Tel: 01895 250230
Case Officer: Michael Gavin
Email: MGavin@hillingsdon.gov.uk
Date: 12th July 2021
Our Ref: 40711/PRC/2021/102

RE: Amendment to roof and building levels and reduction in density from 2 x 3 Bedroom and 4 x 2 Bedroom flats as previously approved under 40711/APP/2018/4033 to 4 x 3 Bedroom flats & 1 x 2 Bedroom flats

SITE: 27 Ducks Hill Road Northwood

GROUND FLOOR

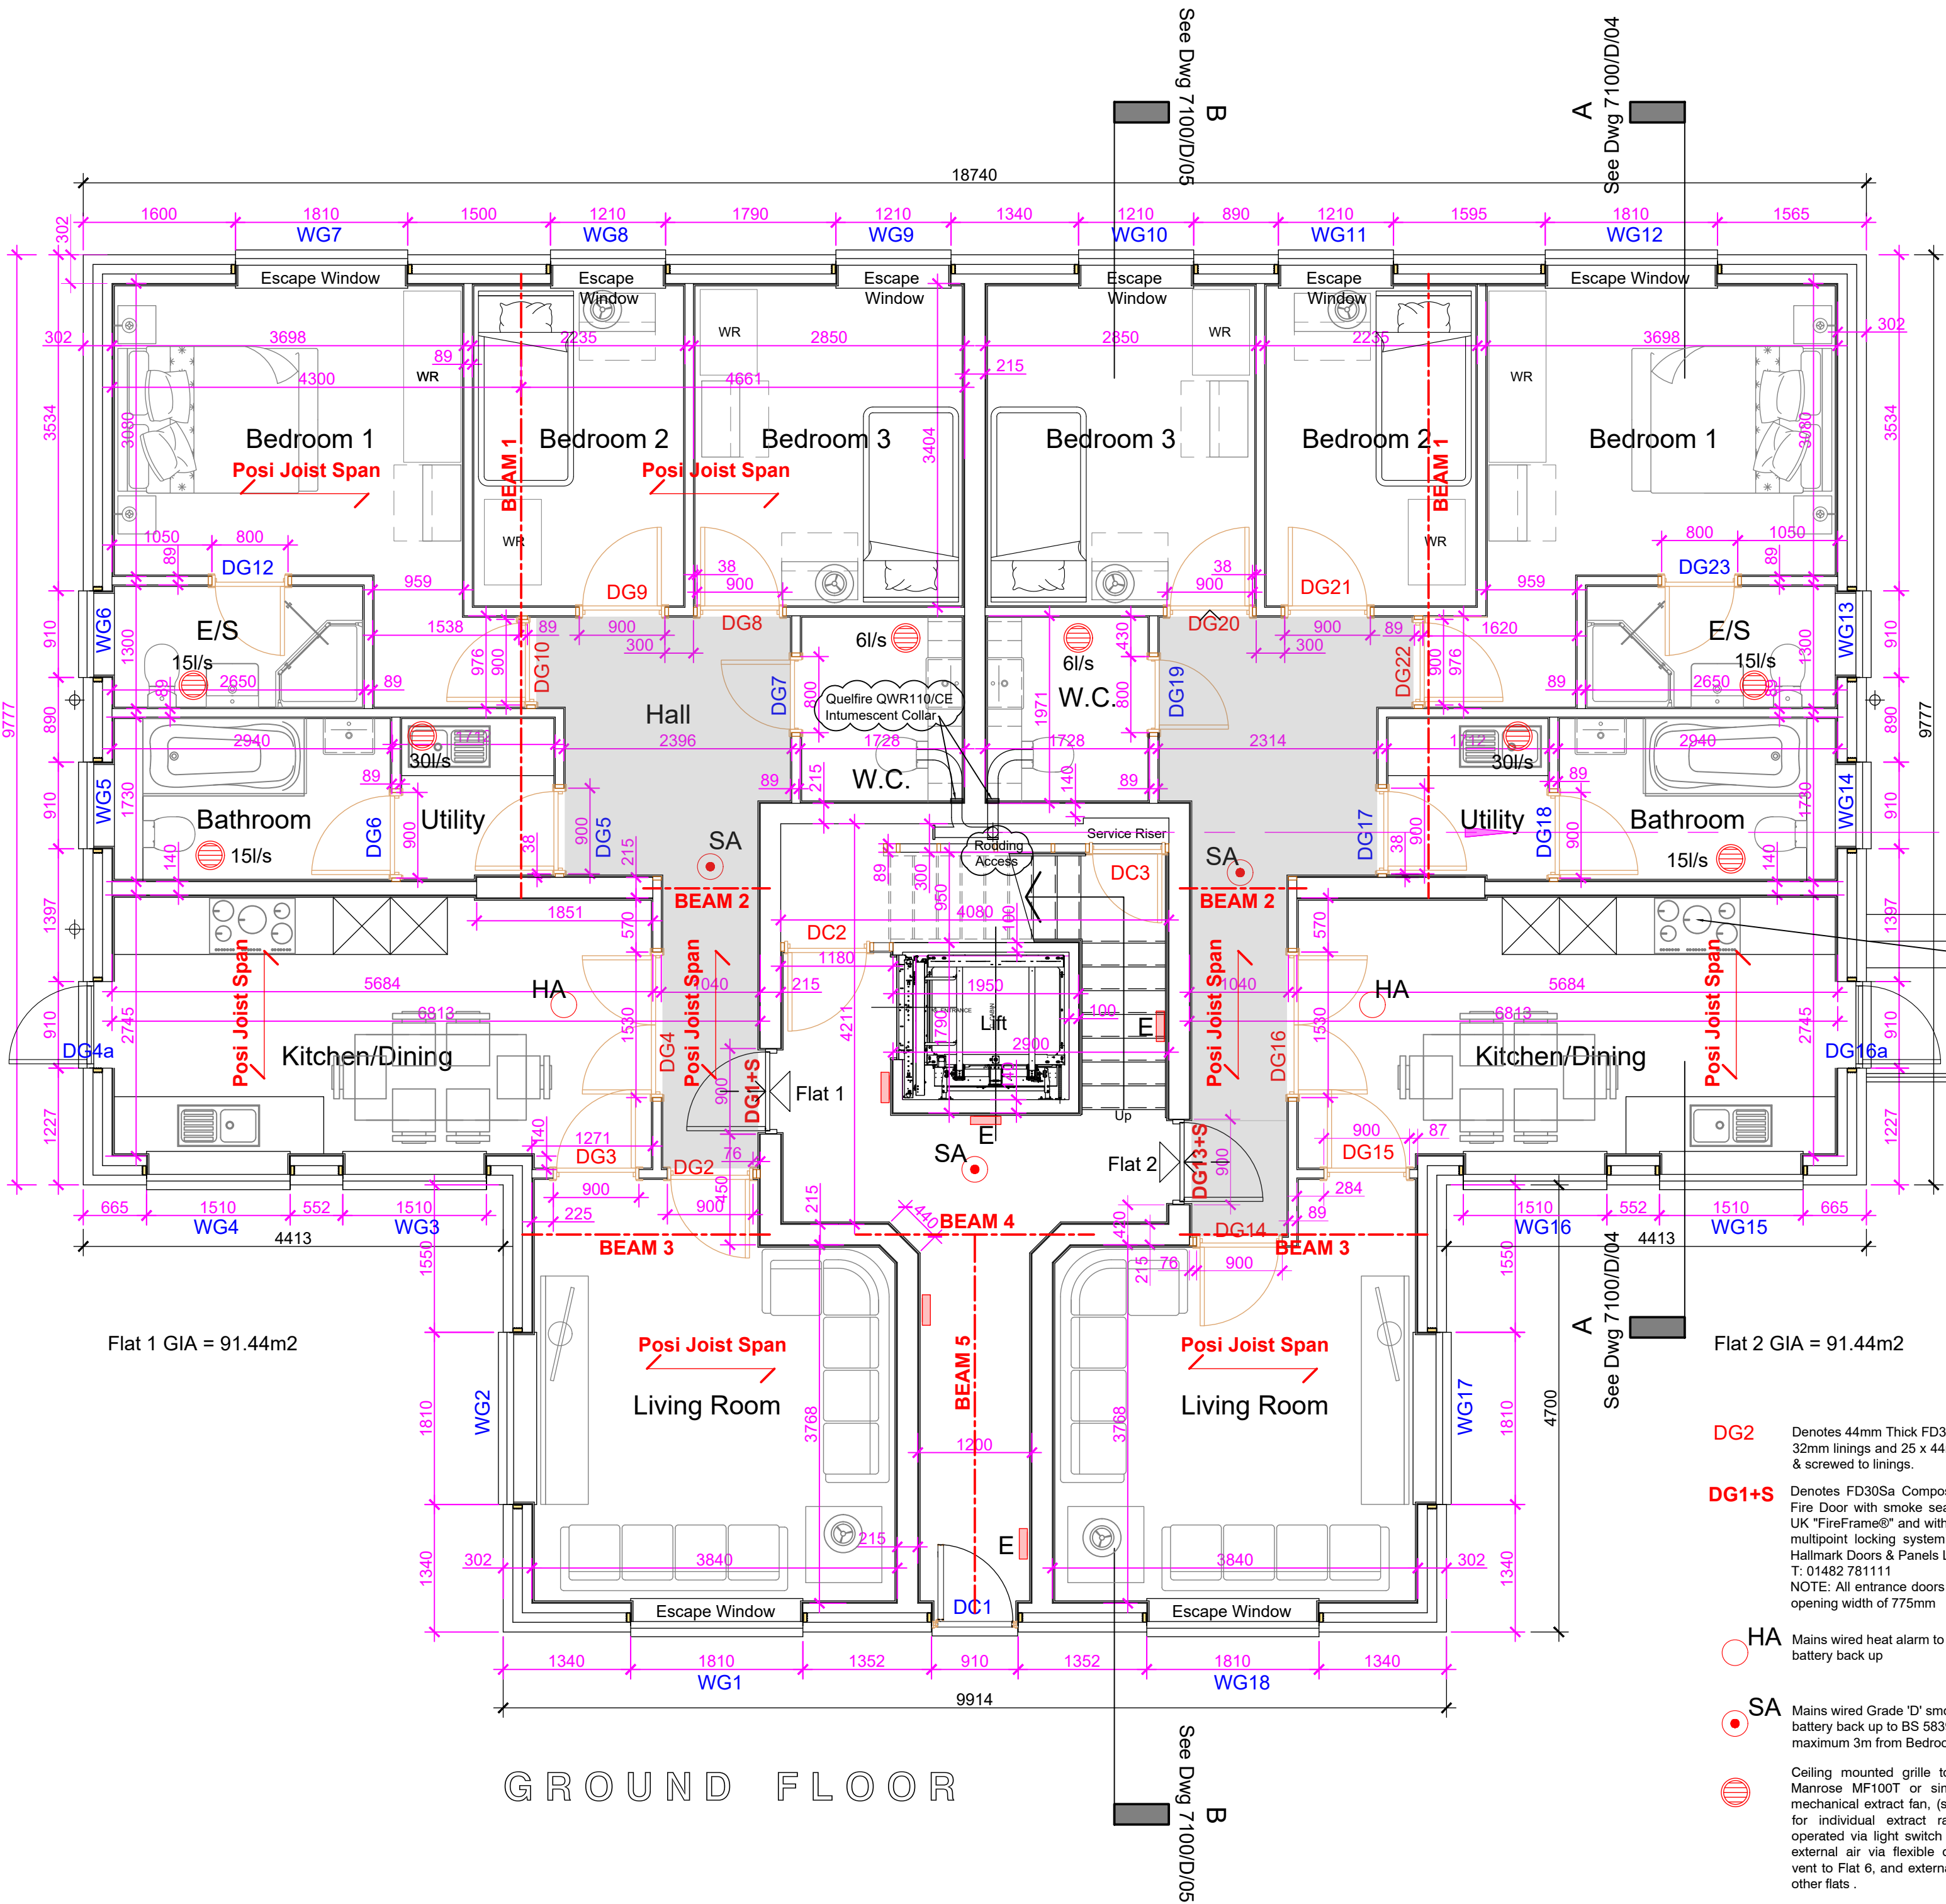
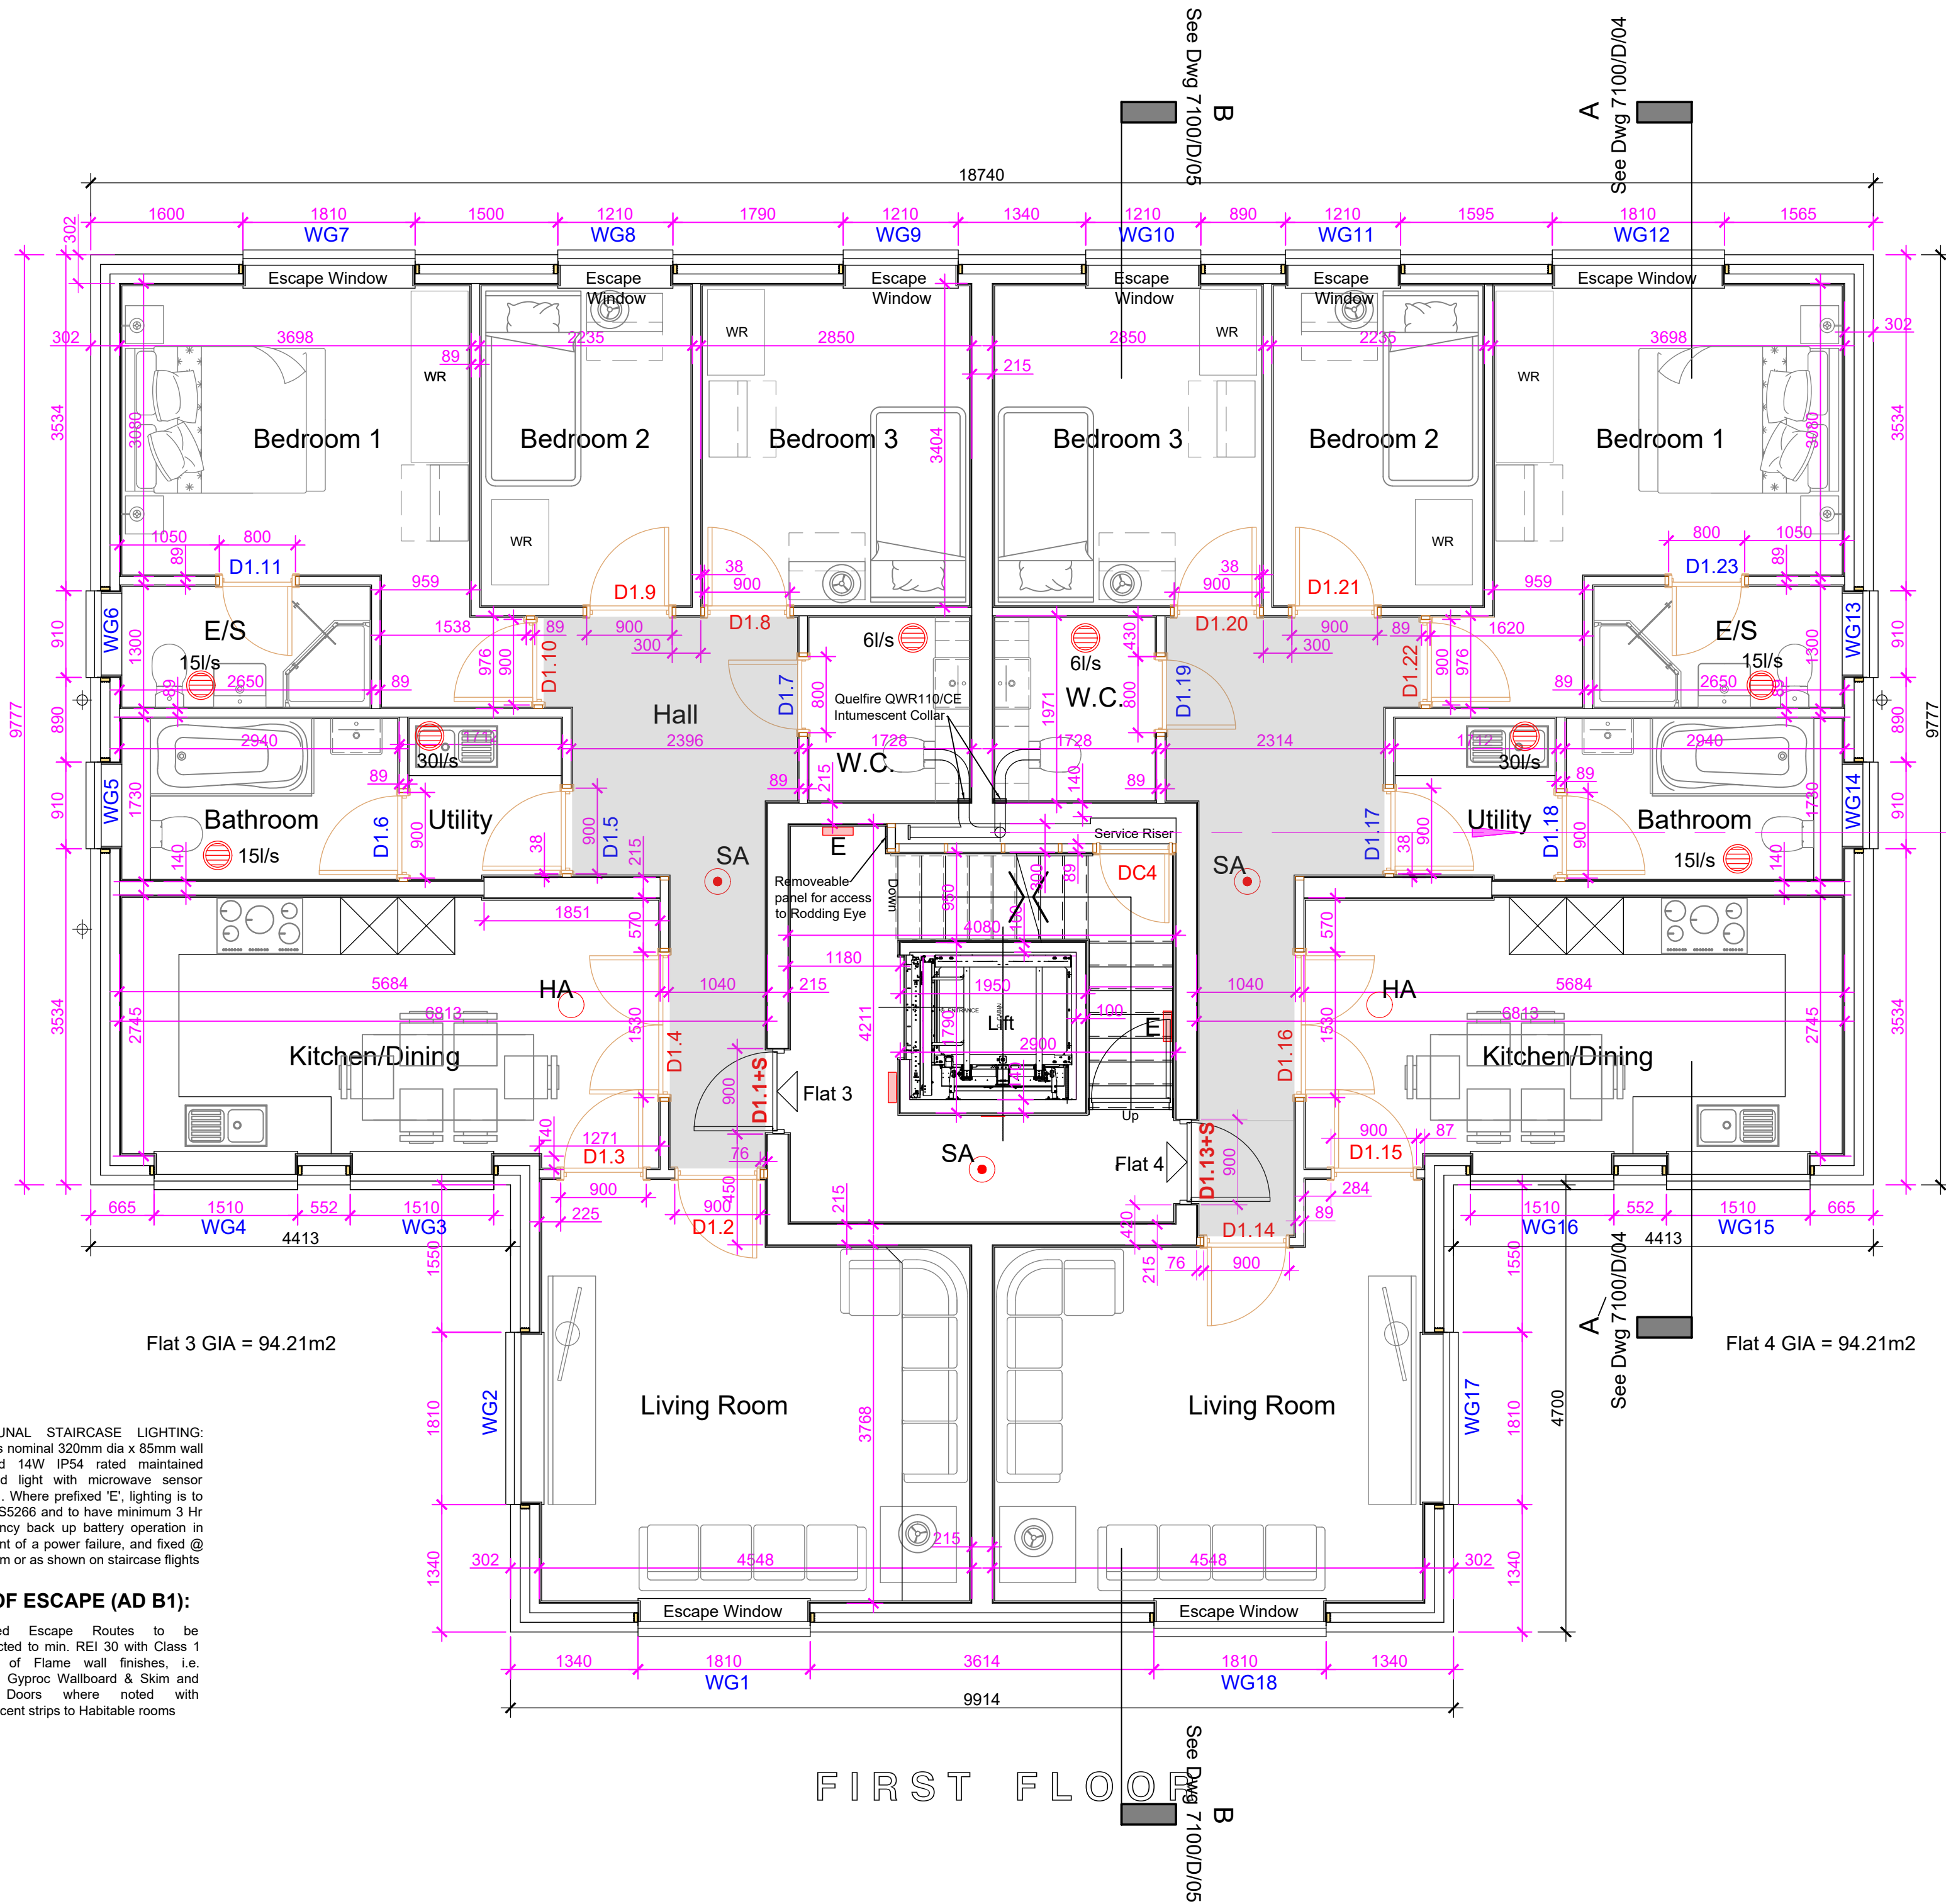
40711/APP/2018/4033 the scheme as amended remains a less attractive building, by virtue of the loss of the overhanging eaves and bulky elevations. As discussed there appears to be scope to reduce the top floor flat in size and still remain in excess of the required GIA for this unit. I appreciate the reasons given in terms of head heights and usability but you may wish to explore further any possibility of further reducing the extent of crown roof over the front projection.

To ensure safe, efficient, and dignified means of escape by people who cannot evacuate by stair, the required passenger lift as shown on plan should be suitable for use during a fire in

Floor plans submitted as part of a planning application should be at a scale of at least 1:100, and should include furnished planned layouts, and clearly demonstrate the access zones and other provisions as set out in Approved Document M to the Building Regulations.
